3 July 2019

**Re: SECTION 4.55 (1A) MODIFICATION APPLICATION TO SSD 7751
BULLI HOSPITAL AGED CARE CENTRE OF EXCELLENCE
22 HOSPITAL ROAD BULLI**

This Modification Application has been prepared by TCG Planning on behalf of Health Infrastructure NSW, seeking consent to modify various aspects of the SSD 7751 approval at 22 Hospital Road, Bulli (the subject site) pursuant to Section 4.55(1A) of the *Environmental Planning and Assessment Act, 1979* (EP&A Act).

DRAWING TITLE
ELEVATIONS - PROPOSED - SHEET 4

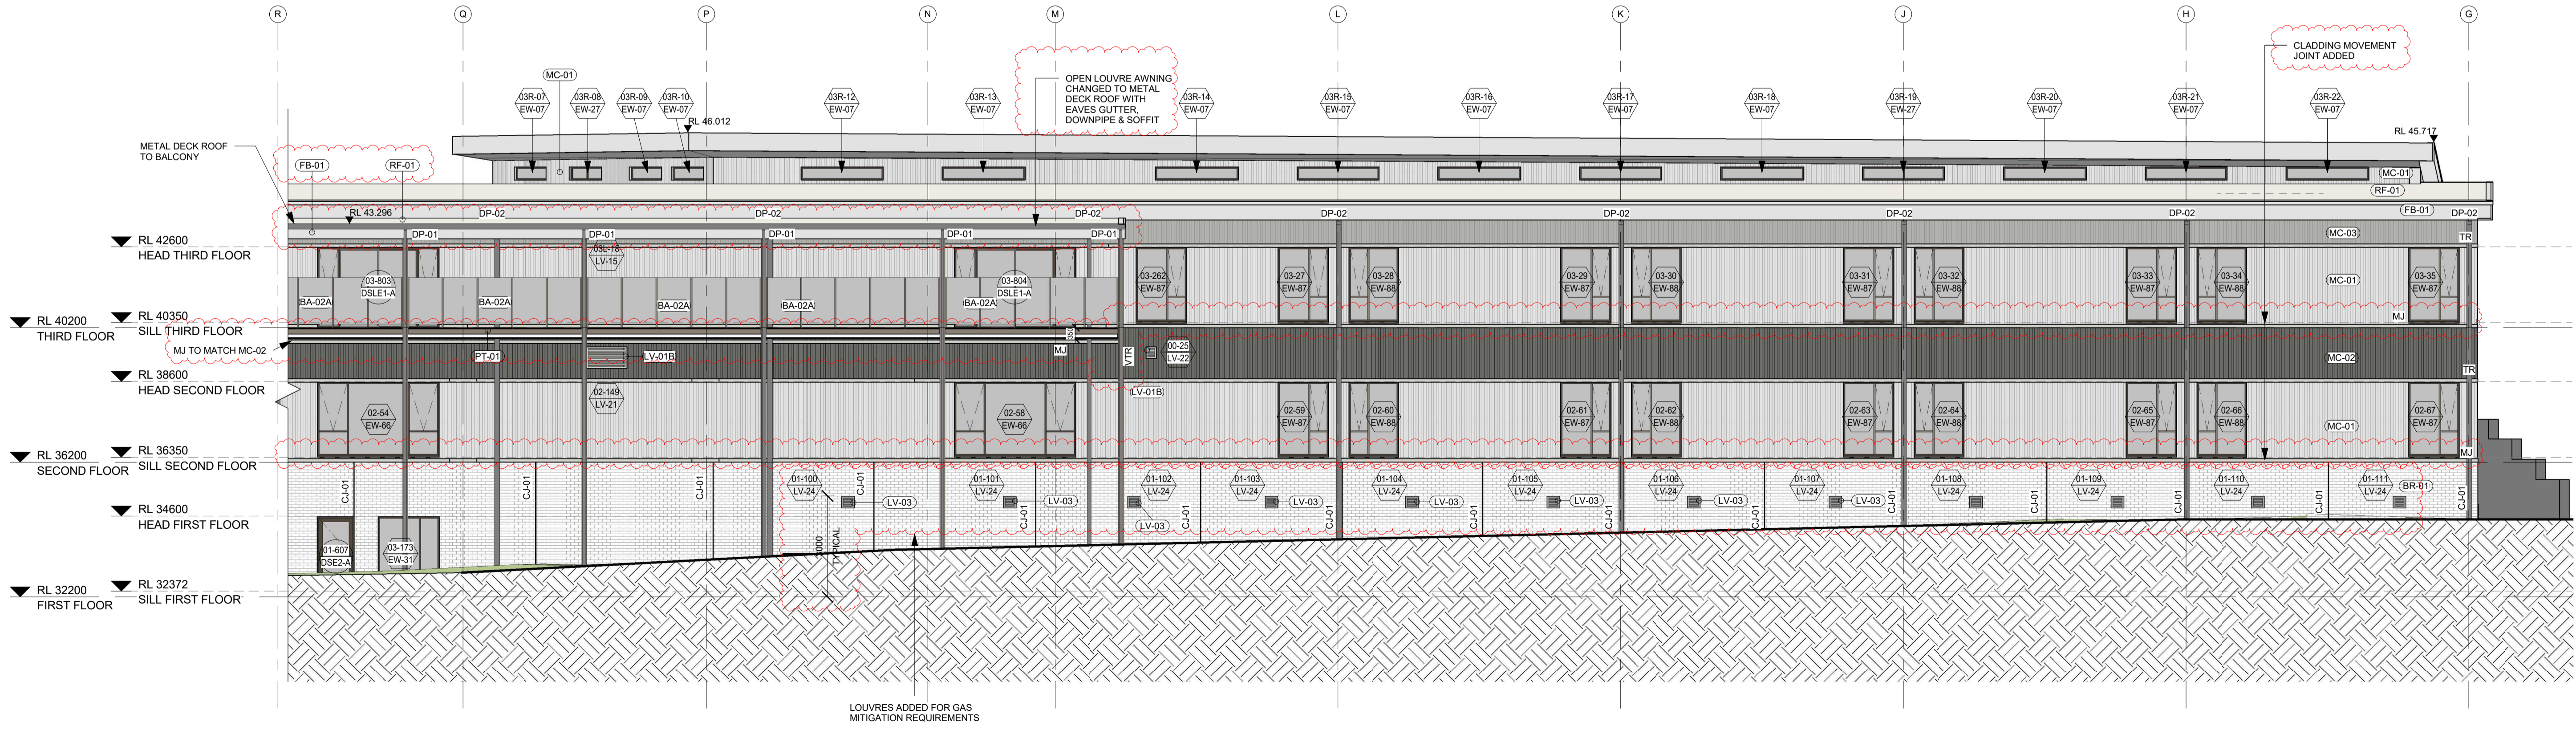
Minor external changes to IRT facility	Billard Leece Plan Dwg: AA-21-0004 and 0005 (Elevation)	Permanent movement joint zone, associated repositioning of window and door to suit; open louvre awning changed to metal deck roof

BULLI AGED CARE CENTRE OF EXCELLENCE
DRAWING TITLE
ELEVATIONS - PROPOSED - SHEET 1

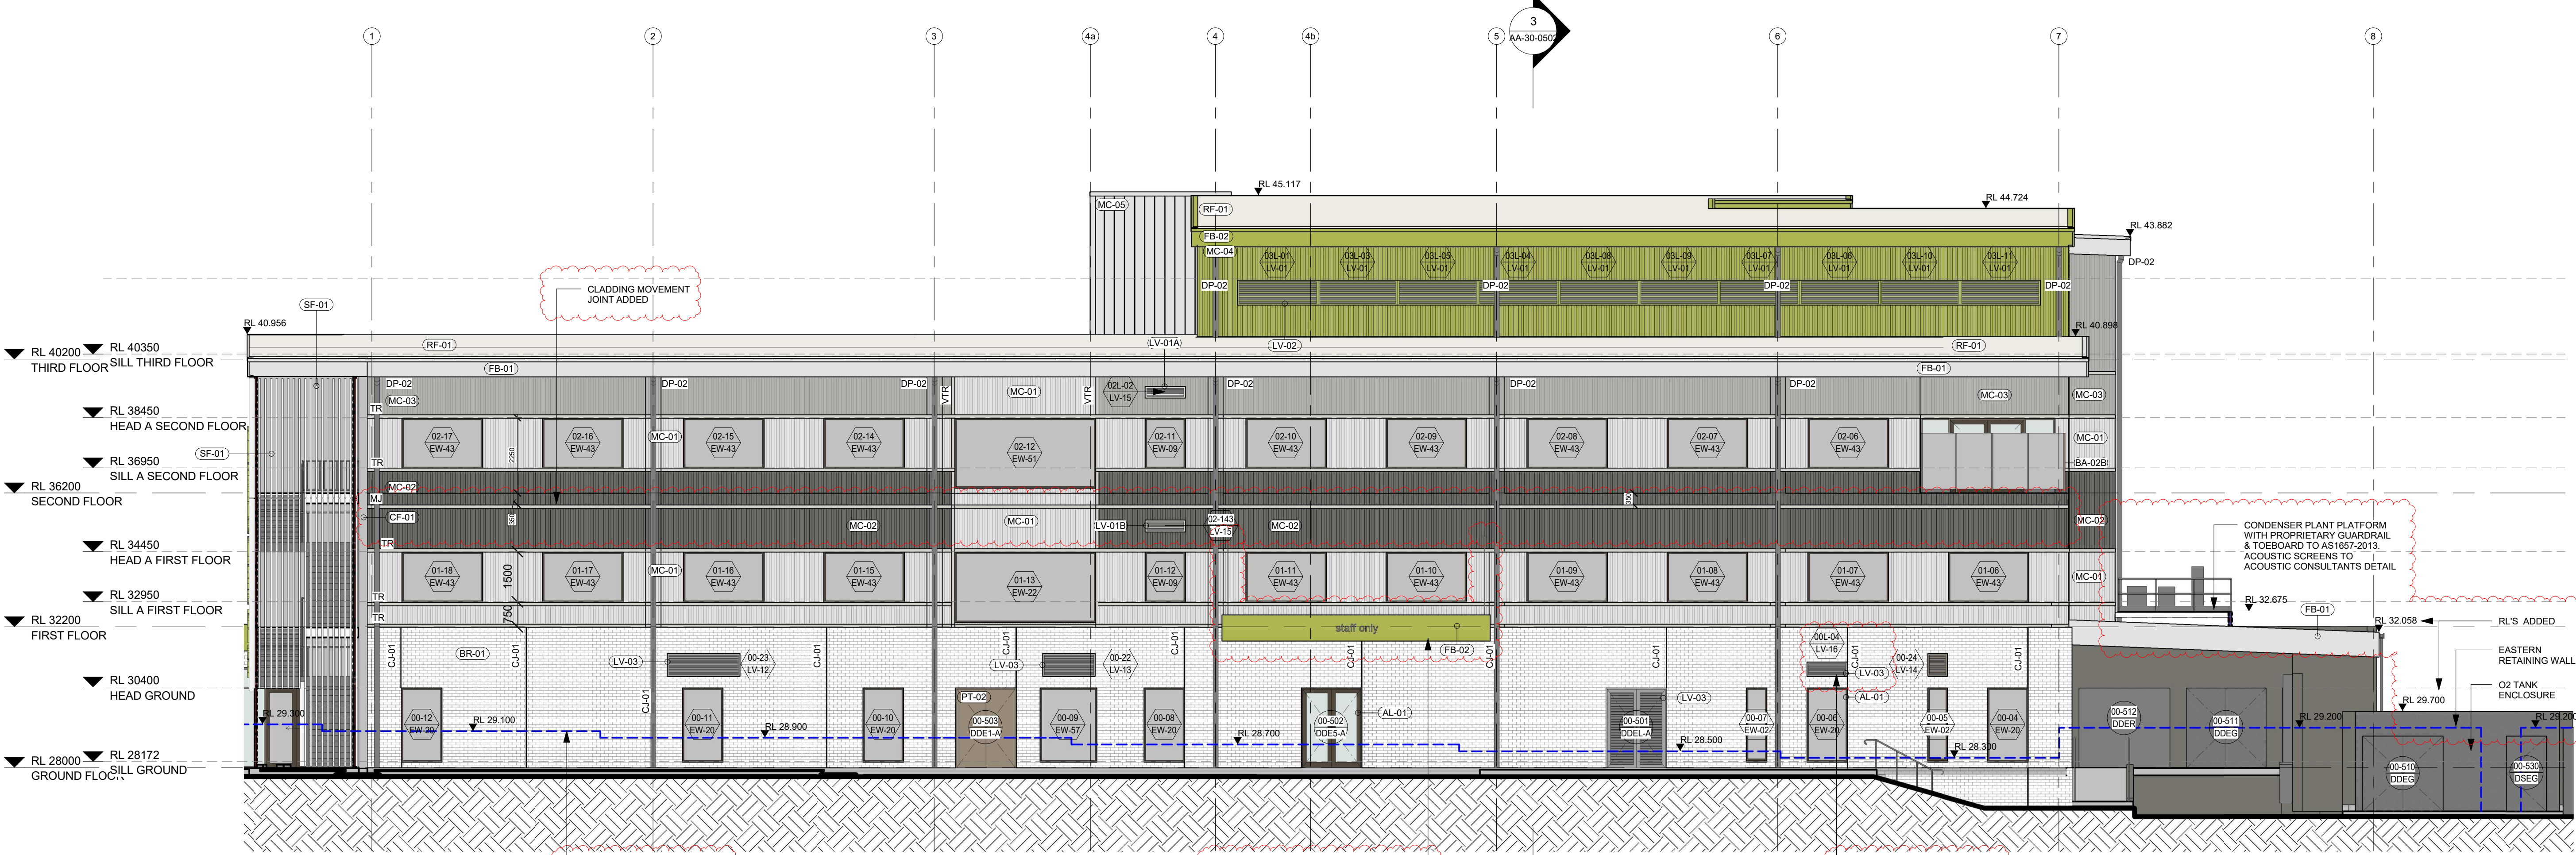
Mechanical Plant – not shown on DA Set	Billard Leece Plan Dwg: AA-06-0101 and Elevations Dwg: AA-21-0001 and AA-21-0002 Correspondence by Acoustic Logic	There are five condenser units that need to be installed in front of Stair 2. Acoustic screens required.
Landscaping Changes – deletion of tree	Billard Leece Plan Dwg: AA-06-0101	Deletion of 1 tree adjacent to Car Space No. 18. Concrete slab required in this area to support adjacent retaining wall and crash barrier.
Change building identification sign	Billard Leece Plan Dwg: AA-21-0003 (Elevation)	Main building sign to be changed to reflect name change from "Bulli Aged Care Centre of Excellence" to "Bulli Hospital and Aged Care Centre"
Changes to external materials and finishes (addition of Bike Racks)	as detailed in Materials Schedule Revision 6 dated 18.04.19 provided by Billard Leece Partnerships Pty Ltd	Bike racks added in different location adjacent to car parking areas.
